Appeal Decision

Appeal Ref: APP/R5510/W/21/3283640

72 Harefield Road, Uxbridge UB8 1PL

- The appeal is made under section 78 of the Town and Country Planning Act 1990 against a refusal to grant planning permission.
 - The appeal is made by Mr Dempsey of Twiglets Developments Limited against the decision of the Council of the London Borough of Hillingdon.
 - The application Ref 25767/APP/2021/491, dated 1 February 2021, was refused by notice dated 5 August 2021.
 - The development proposed is described on the application form as 'demolition of existing dwelling and erection of proposed new flats comprising of 9 dwellings'.
-

PROPOSED FRONT ELEVATION
SCALE - 1:200

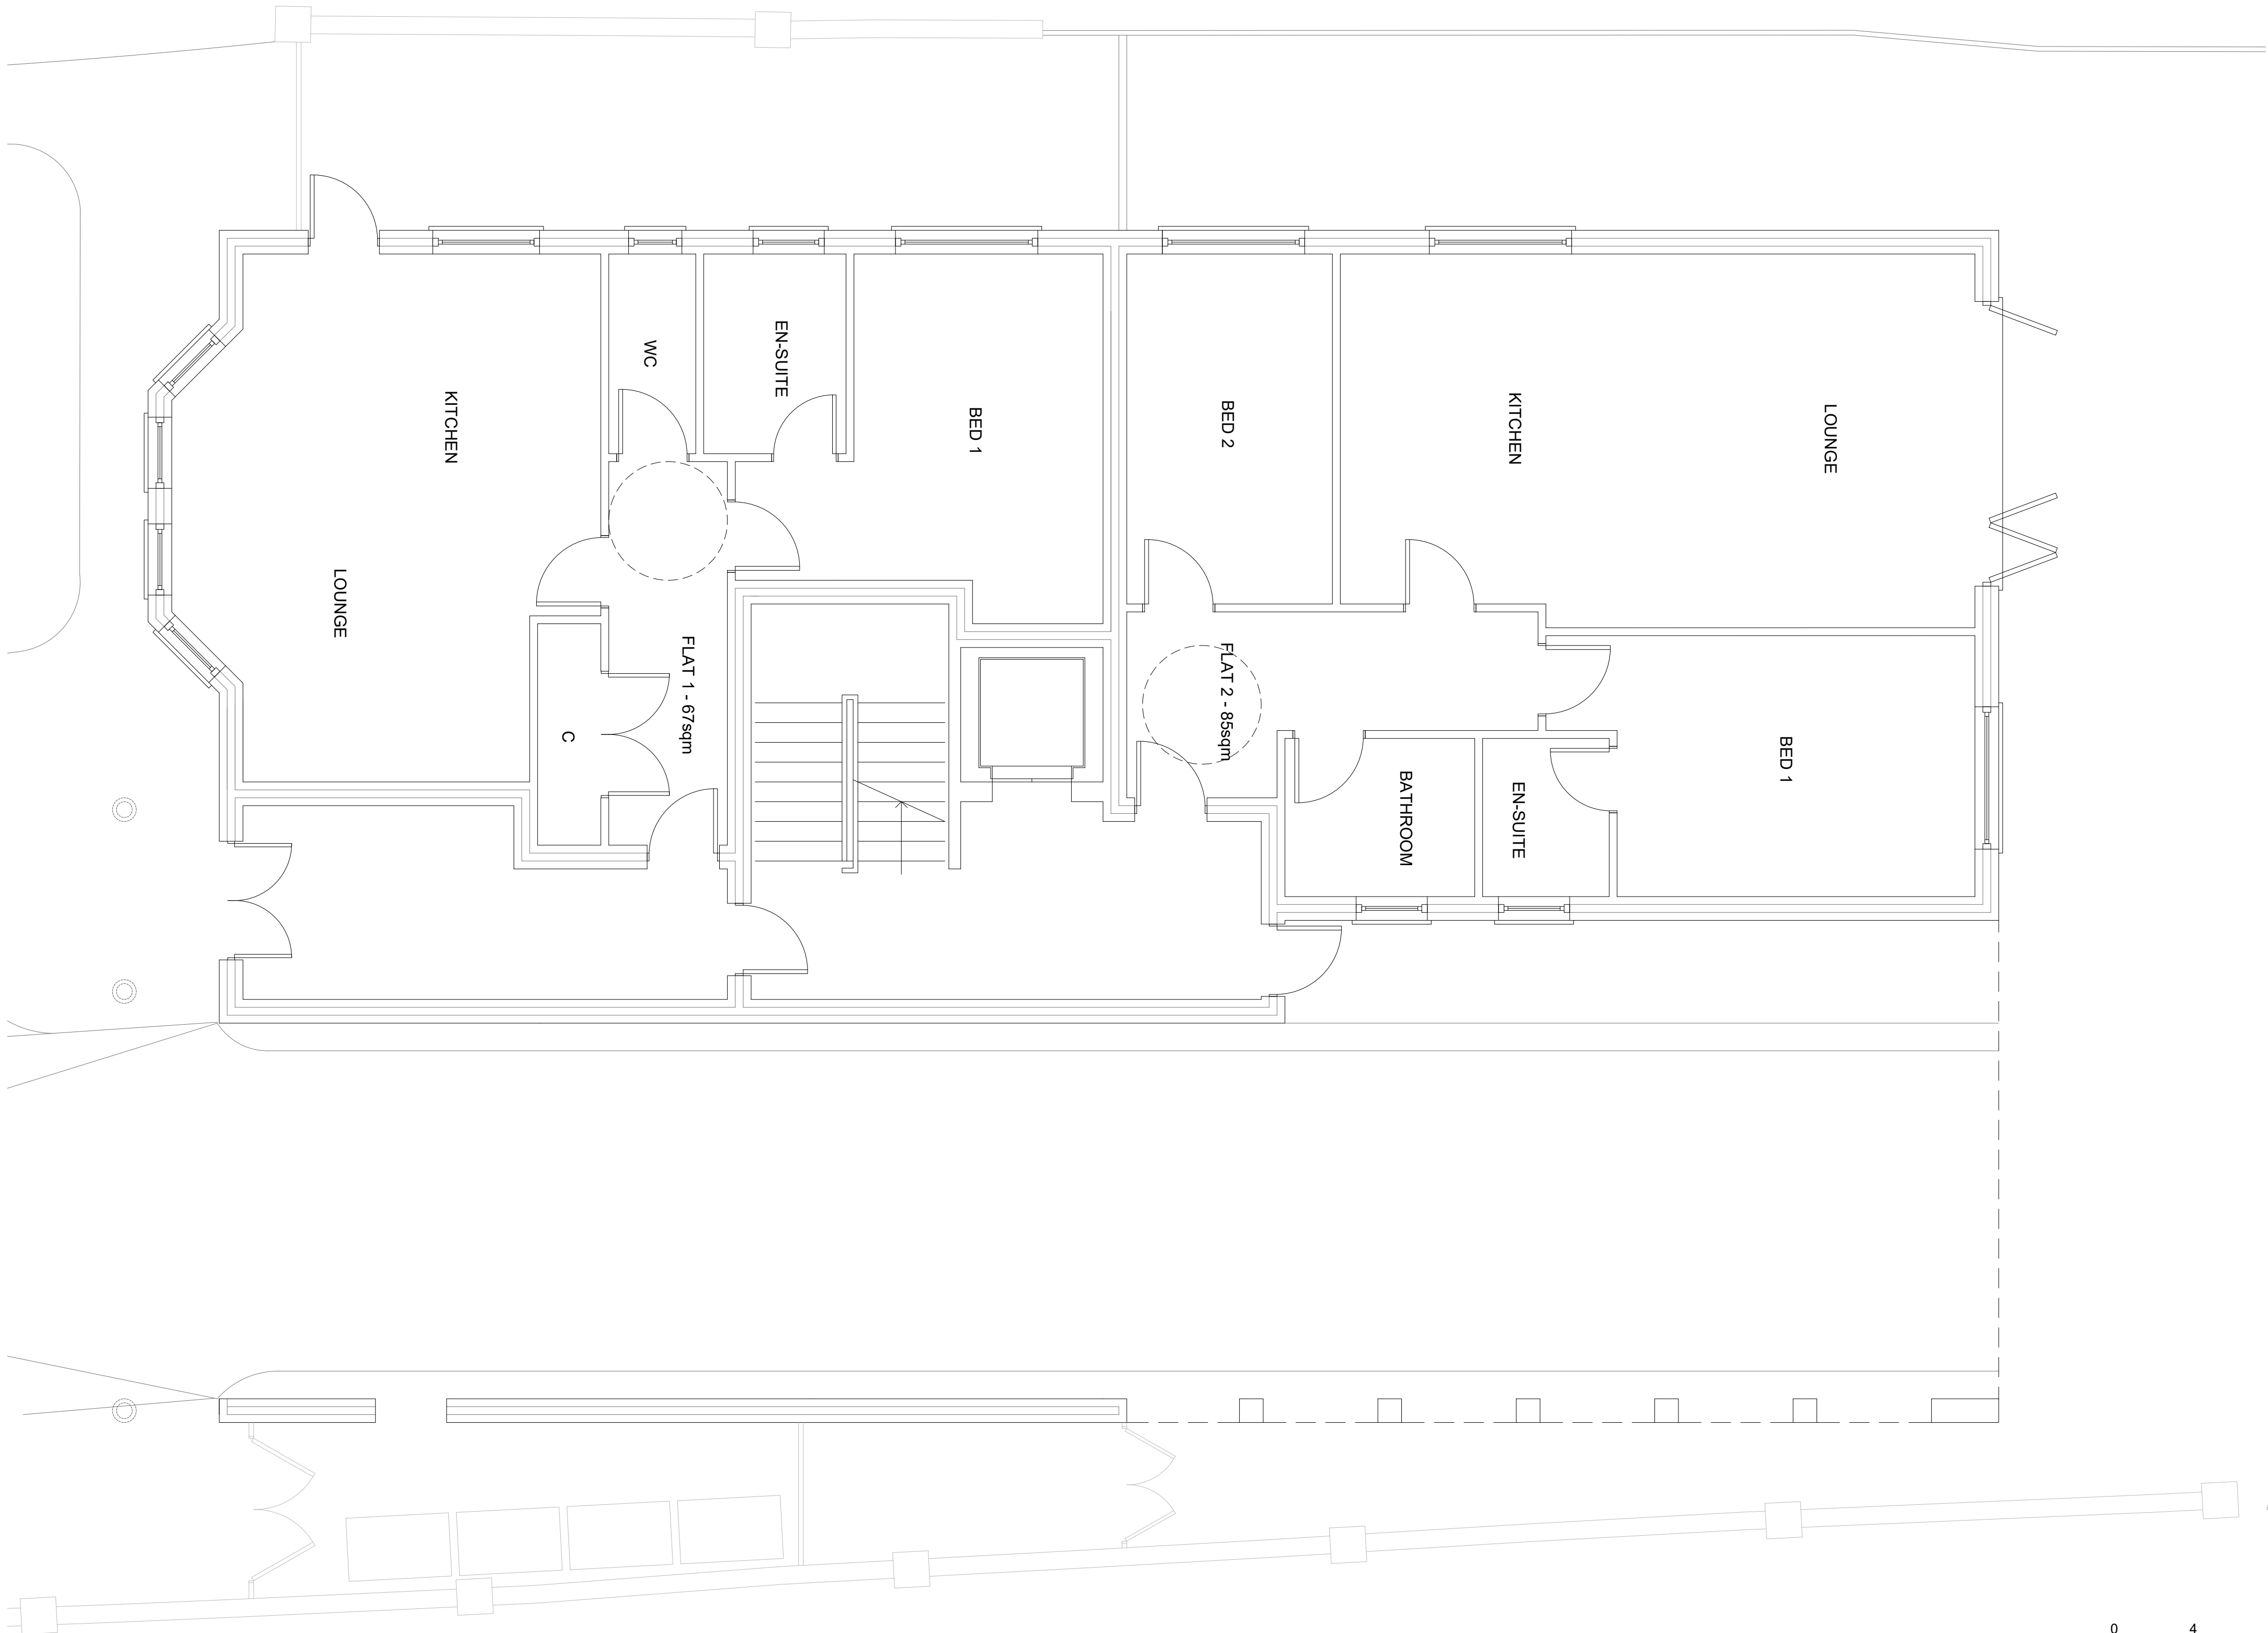
5. The ridge level of the proposed development would be increased substantially, to bring it more in line with that of No 74 and above that of Nos 56-60. The currently sloped nature of the front garden would be excavated, with a lower ground floor created and made level with the highway. The building would

ultimately rise to four storeys in height, compared with the existing two storeys.

6. I acknowledge that the proposed development has taken some of its design cues from No 74. However, the scale of these features, which includes the front bays and 'stretched' dual pitch roof arrangement which obscures the crown roof behind, is far in excess of, and out of proportion with, this neighbouring property. Taken as a whole, the proposed building would be viewed as an overly large and bulky feature within the context of the surrounding townscape. Moreover, the proposed development, which would fill substantially more of the width of the site than is currently the case, would reduce the verdancy of this part of the road. This currently provides a welcome relief from the built form further along the road.

7. I note the appellant's reference to the use of 'crown' roofs in the surrounding area, and the fact that the crown roof proposed at the appeal site would be concealed from view behind the dual pitch arrangement at the front of the property. I agree that this element would not be readily visible from any public vantage point. However, this fact does not overcome the harm that I have identified above.

PROPOSED FRONT ELEVATION
SCALE - 1:200

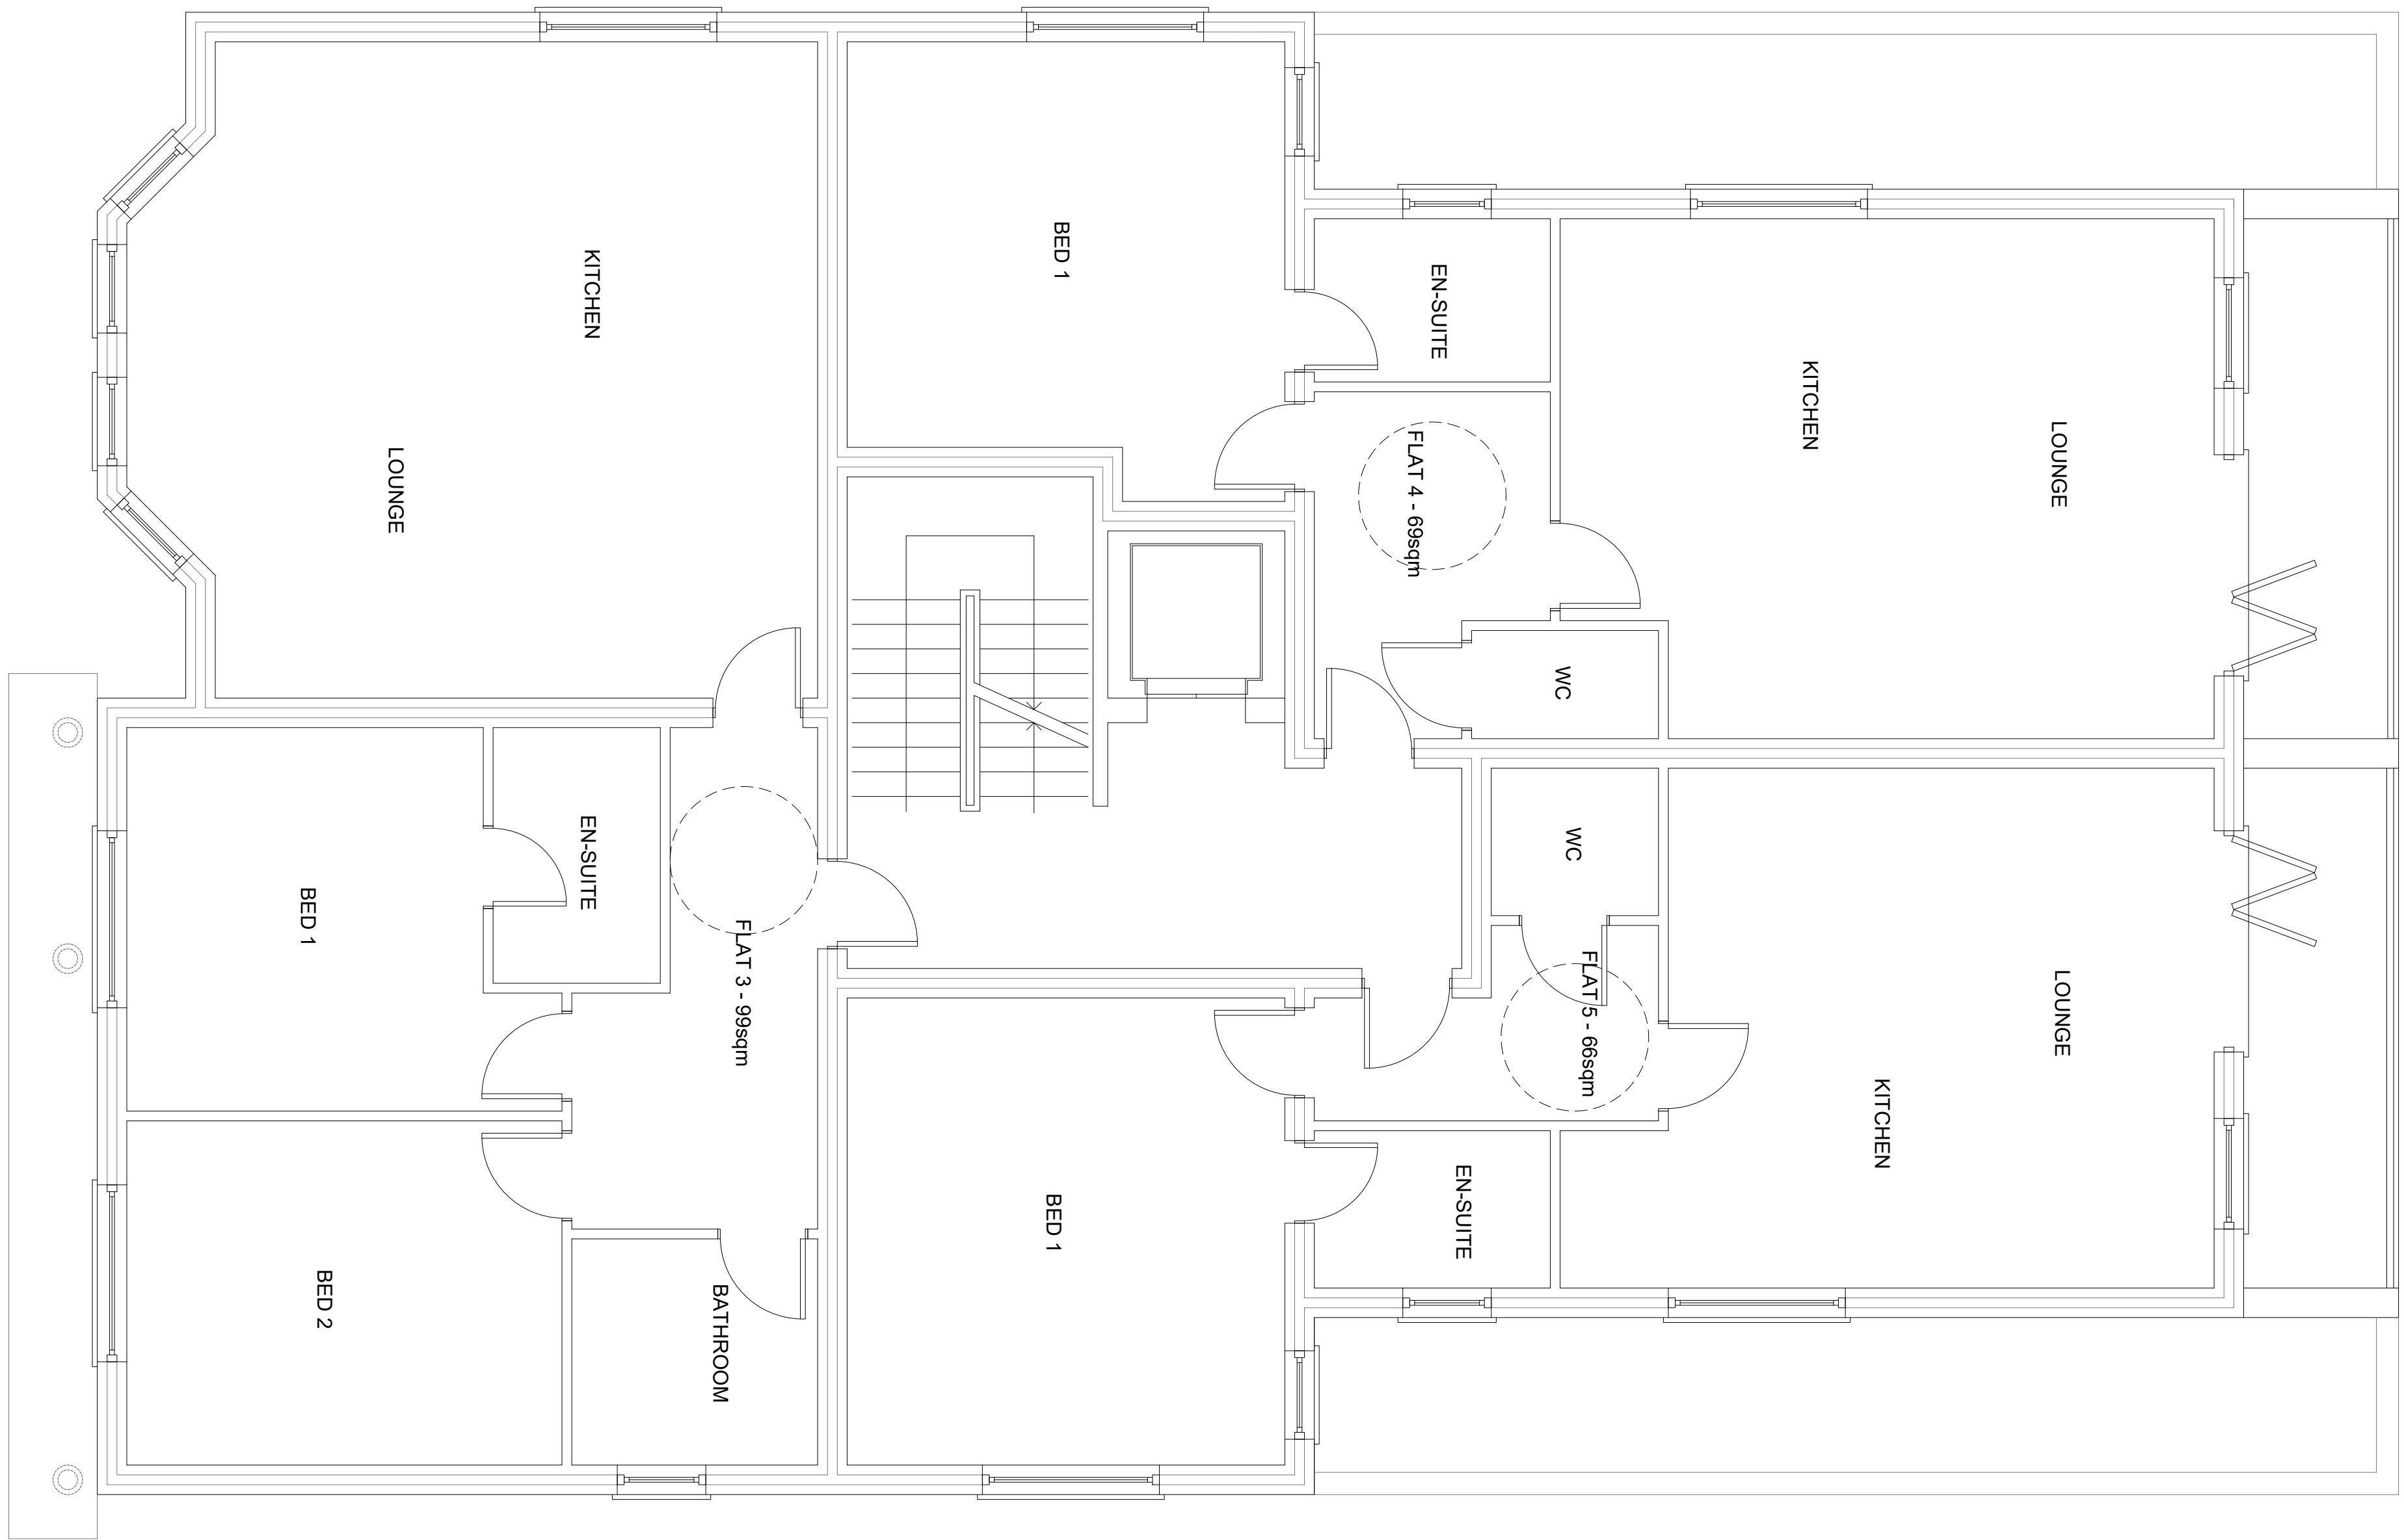
11. The development proposed would extend much further into the plot than the existing property does. Built form on the site would increase substantially, both in terms of height and bulk, rising from two storeys to four. For these reasons

the proposed development would undoubtedly change the relationship of the site with neighbouring properties.

12. Several side and rear facing windows exist at No 74. This includes on both the rear outrigger and the main building. Some of these windows are positioned at lower ground level and are therefore already compromised to an extent in terms of daylight and outlook. Whilst I acknowledge that some of these windows serve non-habitable rooms formed of bathrooms or hallways, and others may be secondary, this is clearly not the case in all areas. The proposed development would bring more substantial built form closer to this property than currently exists, to the detriment of the living conditions of the occupiers of No 74.

13. The proposed four storey mass of the main building, including its rear element, would reduce outlook from a number of flats and generally form an overbearing and oppressive feature when viewed from within No 74. This is reinforced by my reasoning in respect of the first main issue; it follows from the proposal being incongruous that it would entail effects to living conditions which are not in line with the prevailing baseline here. The development proposed would also feel overbearing to users of the areas of amenity space that exist to the side and rear of No 74 by reason of the overall height and scale of the proposed development.

14. The appellant contends that the Council's 45-degree test (the method of taking a 45-degree angle from the centre of a window and locating any extension as far from this as possible to reduce impact on occupiers) has been adhered to and as such demonstrates that the proposed development is appropriately set back in terms of outlook. However, such a method is only used as a rule of thumb and would typically be applied in the straightforward assessment of daylight impacts of development proposals (addressed below). Outlook is multifaceted and can only be properly assessed on a site-specific basis. For the foregoing reasons, in this case, outlook would be unacceptably impacted by the proposed development.
